Rezoning Transportation Analysis
Petition Number: Insert Zoning Petition # 2021-031
General Location Identifier: Tax ID 15503211

Revision Log:

Date	Description
03-25-2021	First Review (WB)
04-19-2021	Second Review (WB)
05-27-2021	Third Review (KP)

RZ1.00

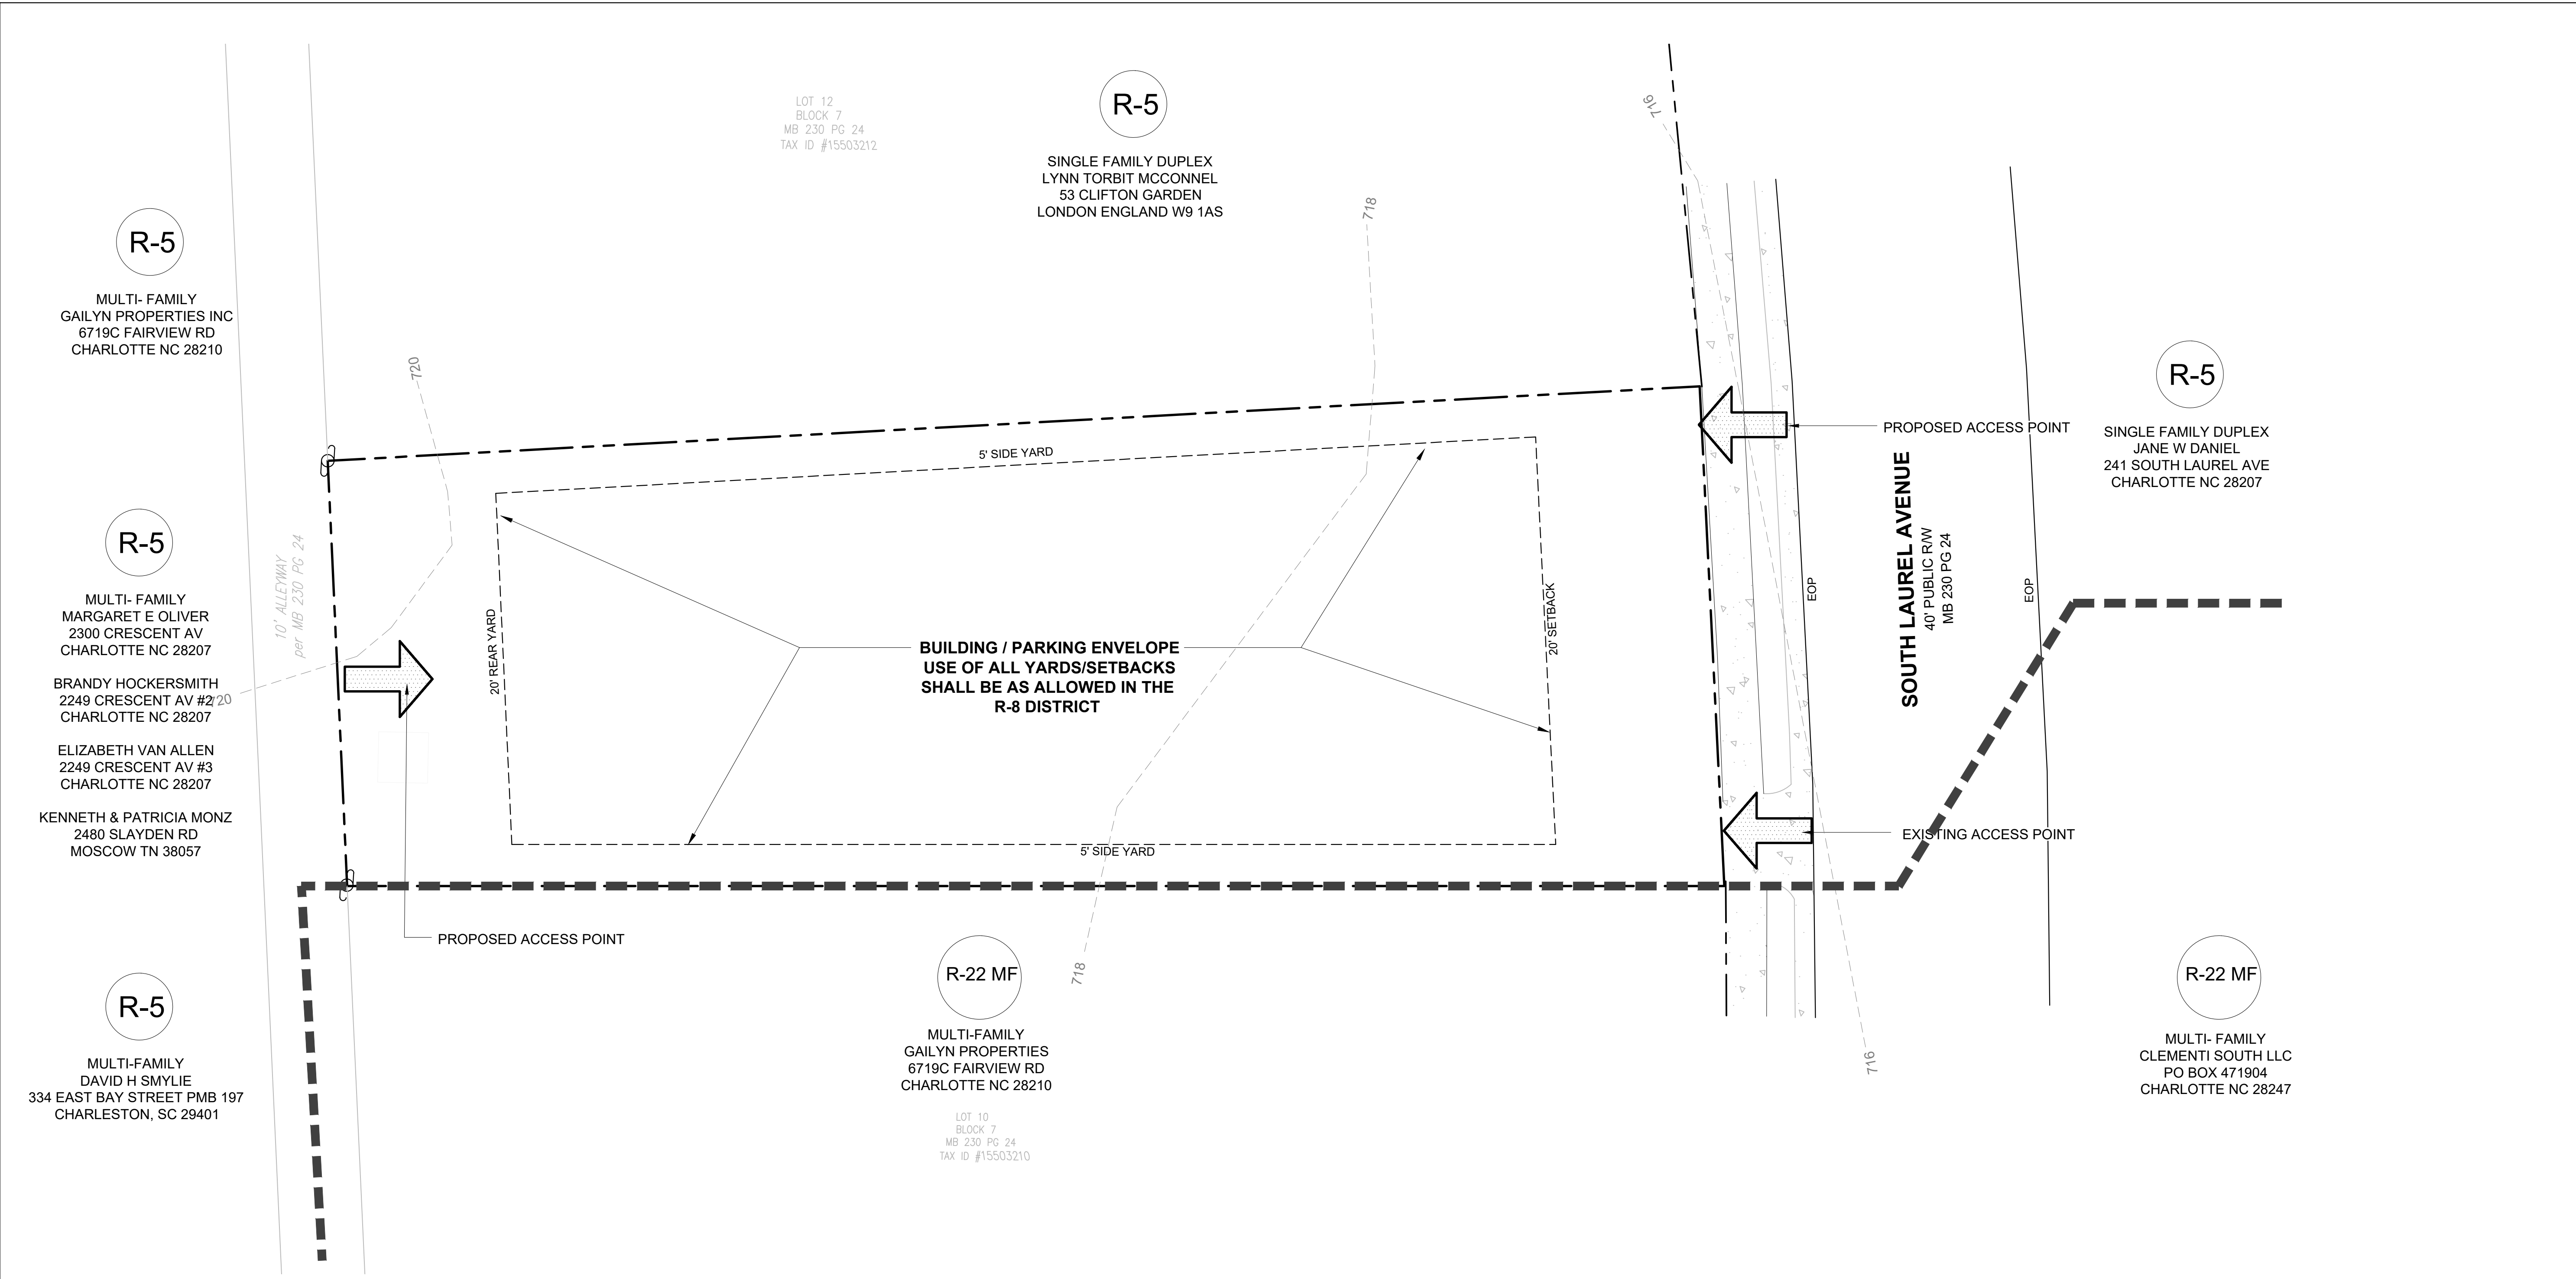
1. ~~**Curbline:** The proposed zoning district has a setback measured from back of the existing or proposed future curbline.~~
 - a. ~~**South Laurel Avenue:** The future location of curb and gutter is in its existing location.~~

~~Label and dimension the curb and gutter from the centerline for each road on the site plan.~~

3. ~~Revise site plan and conditional notes to commit to dedicate 30' right-of-way from the road centerline. The site plan shall label and dimension the right-of-way from the road centerline. **RESCINDED based on meeting held on 4/14/2021.**~~

4. ~~Revise site plan and conditional notes to commit to construct a 6-foot sidewalk and an 8-foot planting strip on South Laurel Avenue per CLDSM Standards 11.09. The site plan shall label and dimension both items from the back of curb and gutter and road centerline.~~

~~Reference CLDSM standard detail 11.09 for street typical. **RESCINDED based on updated site plan uploaded on 4/14/2021.**~~

5. ~~There are existing and proposed driveway access points along South Laurel Avenue. Please show the minimum distance between the two site access points on South Laurel Avenue. **RESCINDED based on meeting held on 4/14/2021.**~~

6. ~~Add a site plan note specifying dedication and fee simple conveyance of all rights-of-way to the City before the site's first building certificate of occupancy is issued is needed. CDOT requests rights-of-way set at 2' behind back of sidewalk where feasible. **RESCINDED based on updated site plan uploaded on 4/14/2021.**~~
